# Preferred Project Report

16 Thomas Street Chatswood

MP 09\_0066 MOD 6

21 May 2013

BUILDING 1
ELEVATION - EAST
A-0123
D
SECTION 75 W MODIFICATION 6

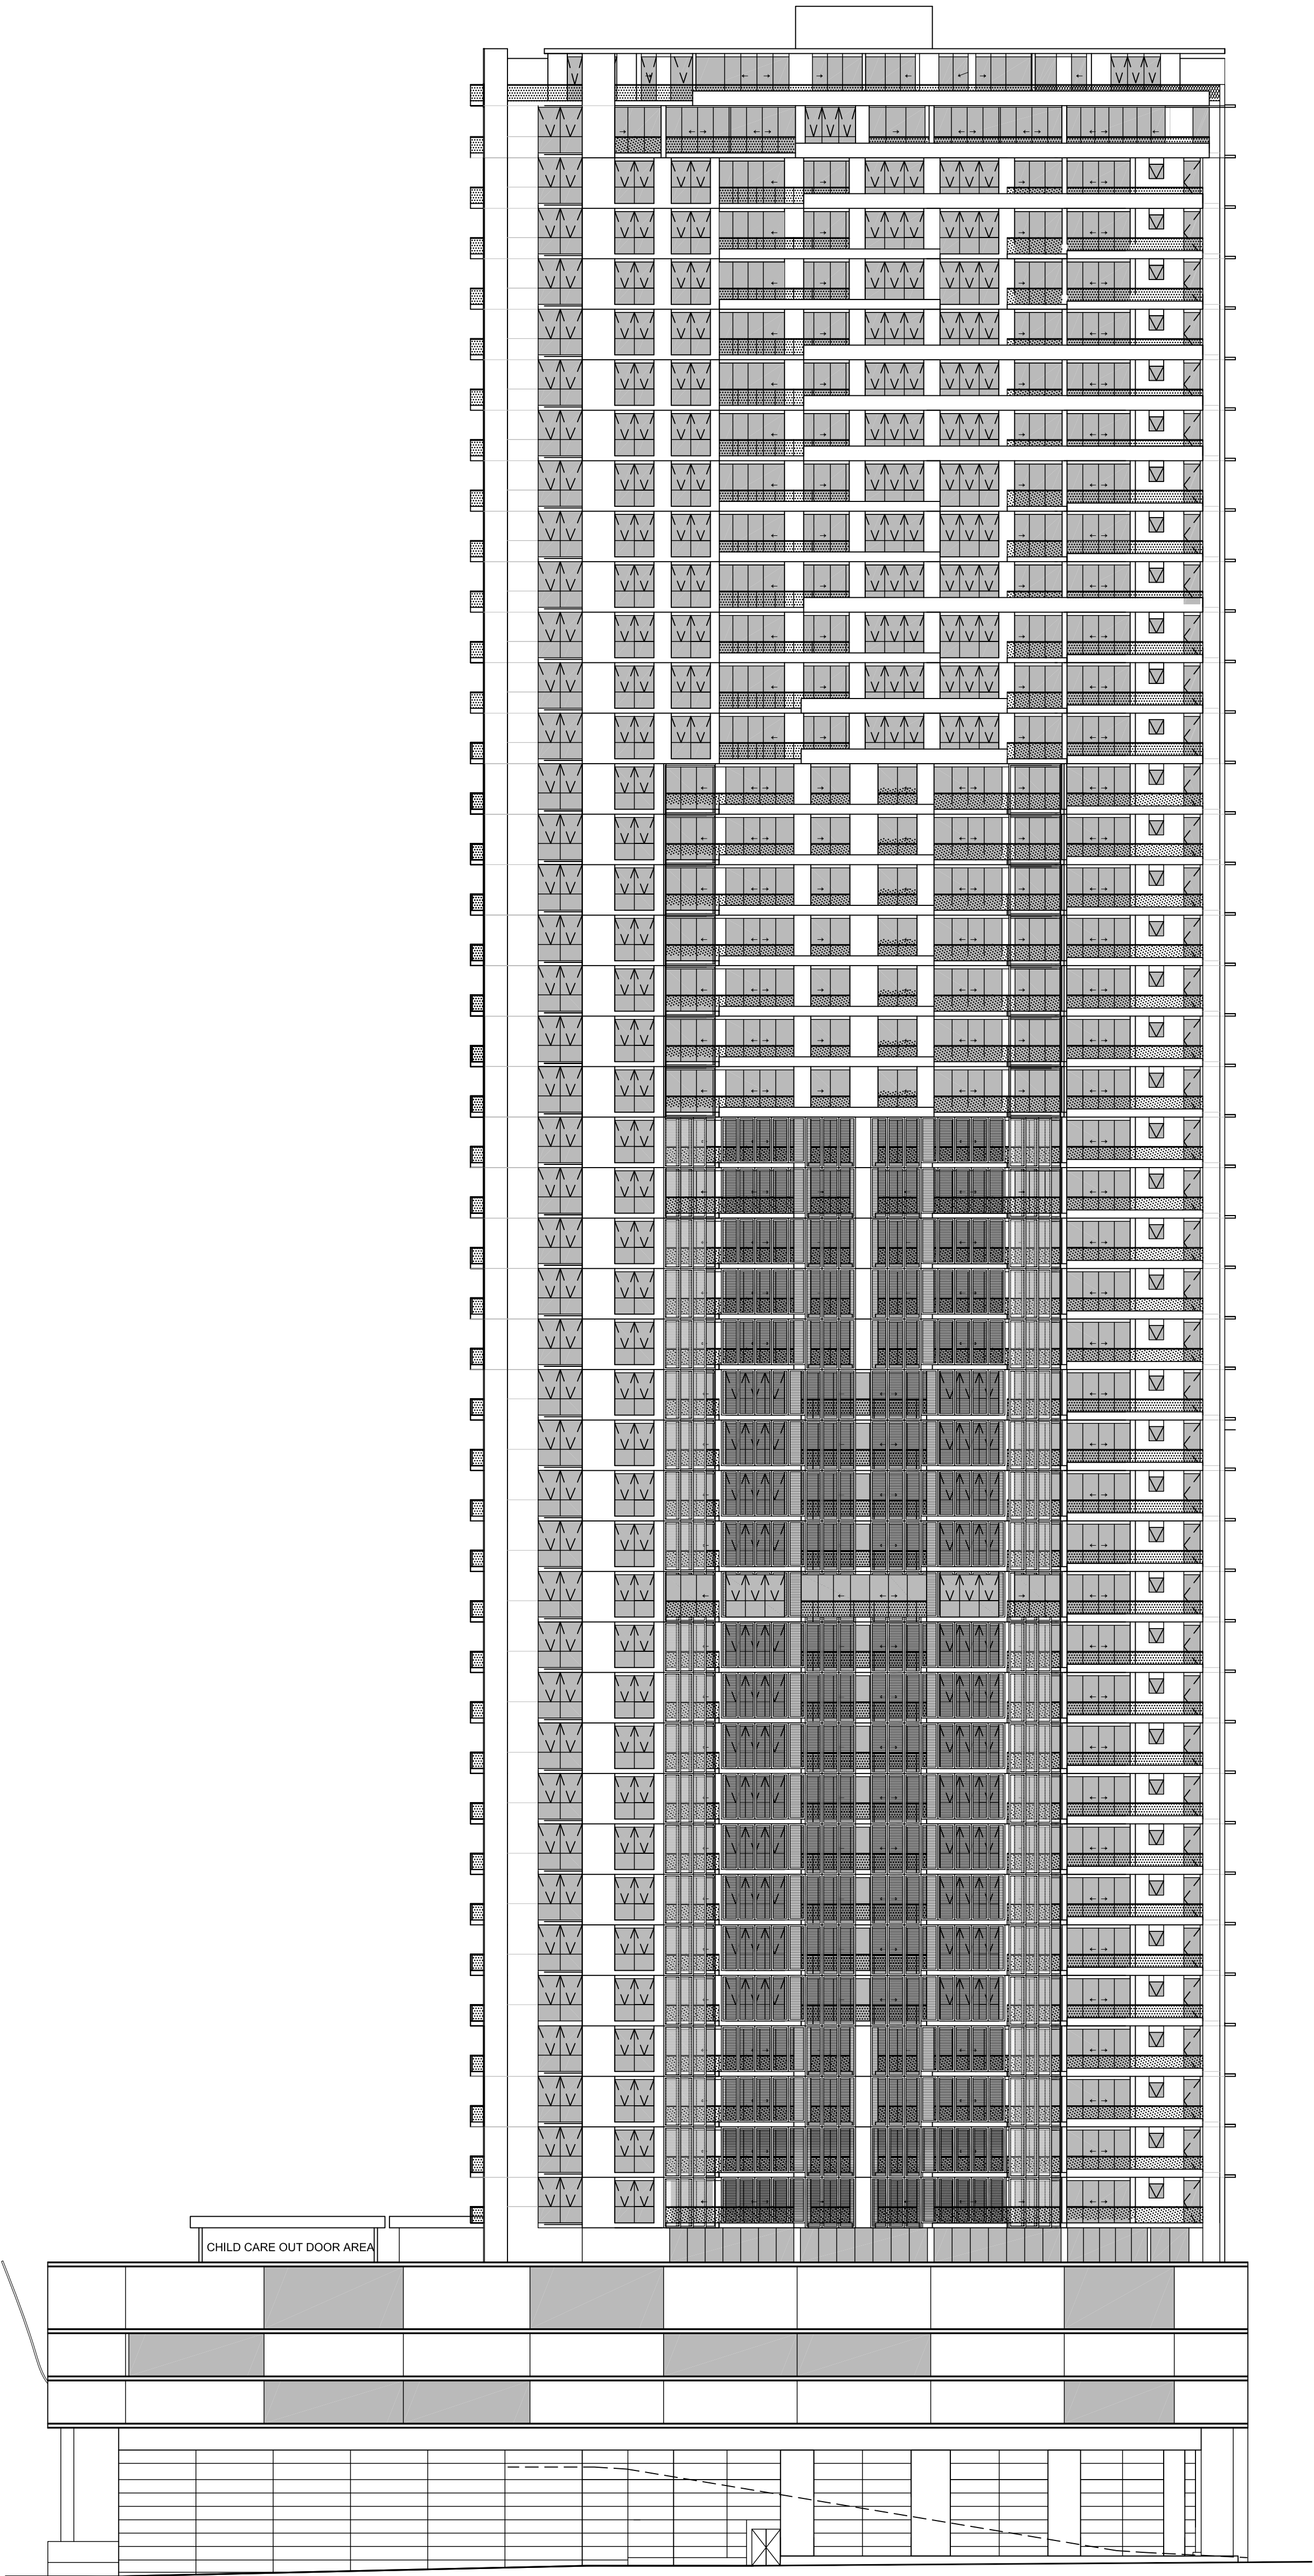
Noting that the above ground car parking as proposed will only be partially skinned, the Department requires confidence that the final design will provide a positive visual impact. Please provide examples and further justification supporting the façade treatments for the podium.

The first 2 aboveground levels along the Thomas Street frontage is located behind units and the third level will consist of building materials that will complement the new podium units as shown in the perspectives attached to **Annexure 5**.

Along the Albert Avenue frontage, units will 'skin' the above ground parking for two levels with a see-through bridge introduced between separated parking areas. This will result in approximately two-thirds of frontage being visually activated. The remaining one third of the frontage and the third level of aboveground parking will consist of building materials that complement the units fronting Albert Avenue.

Approved Alignment

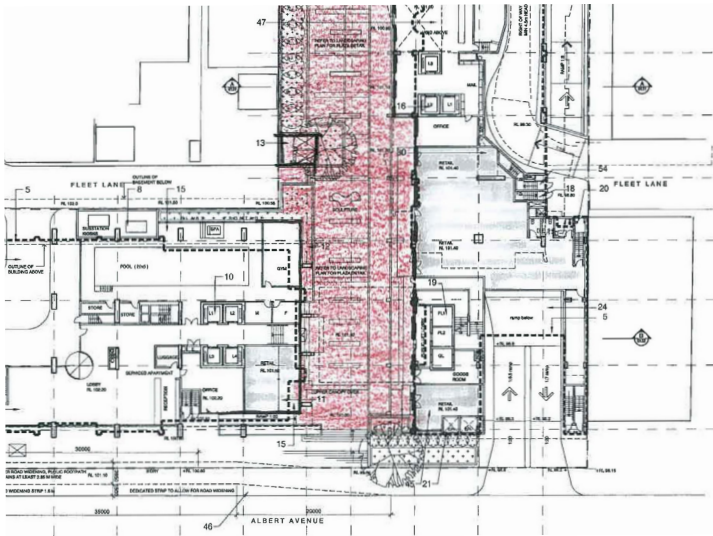
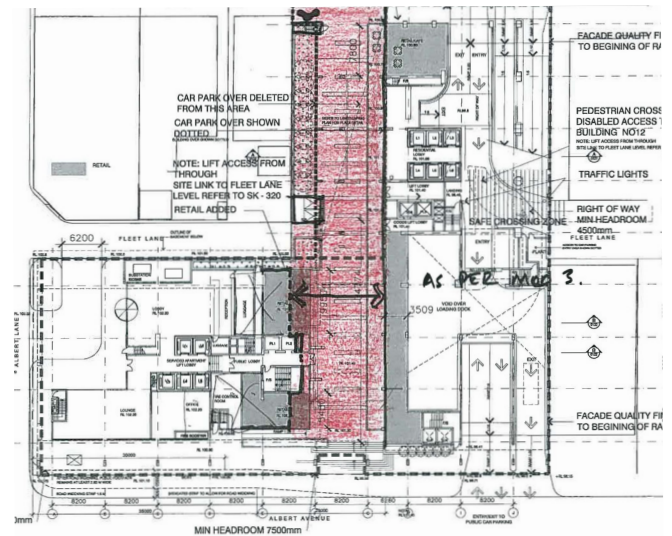
In relation to the Public Plaza/Through site-link, the Department remains concerned with the proposed modification to the public space, in particular it is noted that the proposed modification appears to substantially reduce the width of the public plaza/through site-link. To achieve better pedestrian amenity, the Department seeks that you reconsider the design in particular the width of the through site-link and the height and breadth of the enclosing structure above the link.

The Through Site-link width has been reinstated to the original 2010 approval to achieve better pedestrian amenity. Importantly, the pedestrian amenity will be enhanced further with new retail space at the ground floor of the Serviced Apartment building fronting the pedestrian through site-link. **Annexure 7** shows the MOD 3 approval and compares this against the MOD 6 proposal.
